June 10, 2014

Re: 59 Codman Street

The Department of Public Services received your request on behalf of the property at 59 Codman Street for a second driveway curb cut to accommodate handicap accessibility for the property owner. A city design standard adopted by the City of Portland Planning Board in 2010 allows only a single curb cut per property in residential zones. The basis for this limitation was to restrict the number of access points along streets in the City for improved pedestrian, bicycling and vehicle safety. 59 Codman Street falls within that zone and is limited to a single curb cut for a driveway. Additionally, zoning regulations prohibit parking within 25 feet of the front property line. Our Engineering Division along with the Planning Department denied the request given the conflict with Zoning regulations and our Design Standards. However, the denial can be appealed to my office for further consideration; which as I understand, why you have appealed this denial to me for further consideration.

SITE PLAN

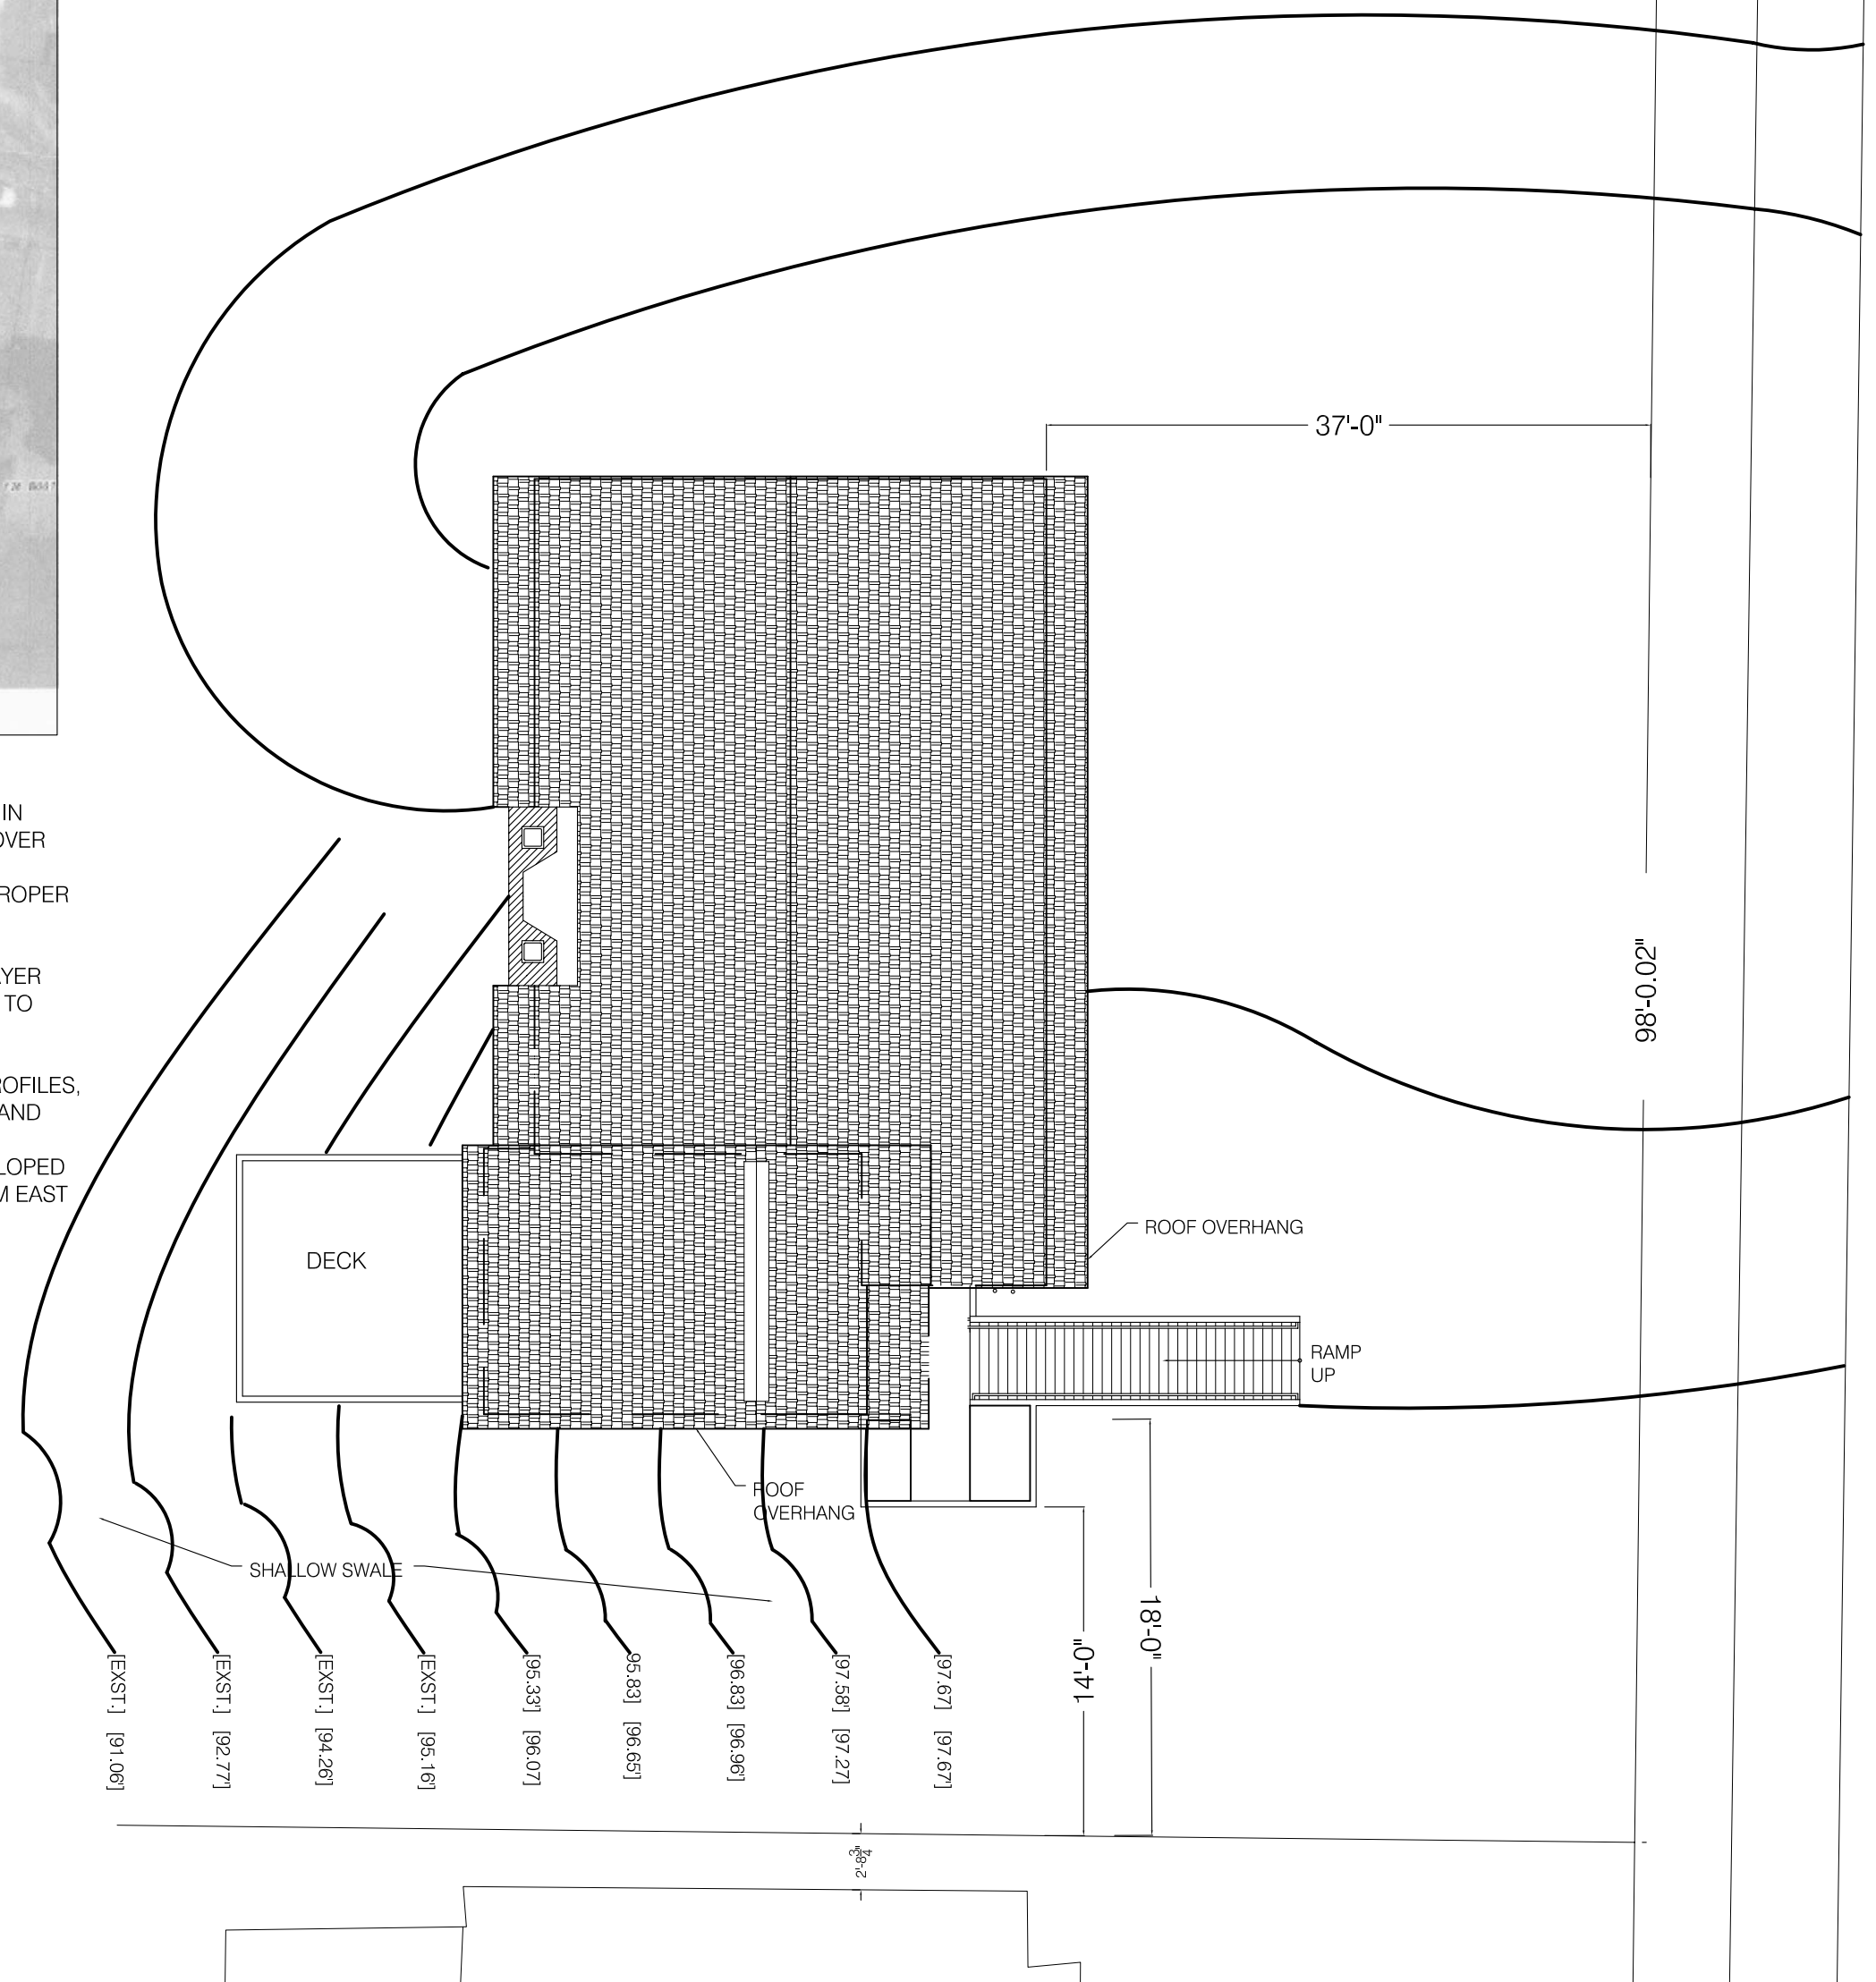
Following further review and discussions with our Engineering staff, and with zoning staff from the Planning Department, I am hereby approving the second curb cut opening at 59 Codman Street for the purpose of accommodating the owner/occupants handicap accessibility needs, with the following conditions:

- Proposed layout and design of the curb cut opening shall be reviewed and approved from a technical and site distance assessment, by our City Transportation Systems Engineer; and the second driveway is to be used for drop off and pick up only, and not for vehicle parking.
- The curb opening will be removed at the owner's expense once the second curb cut is no longer needed for use by the homeowner.
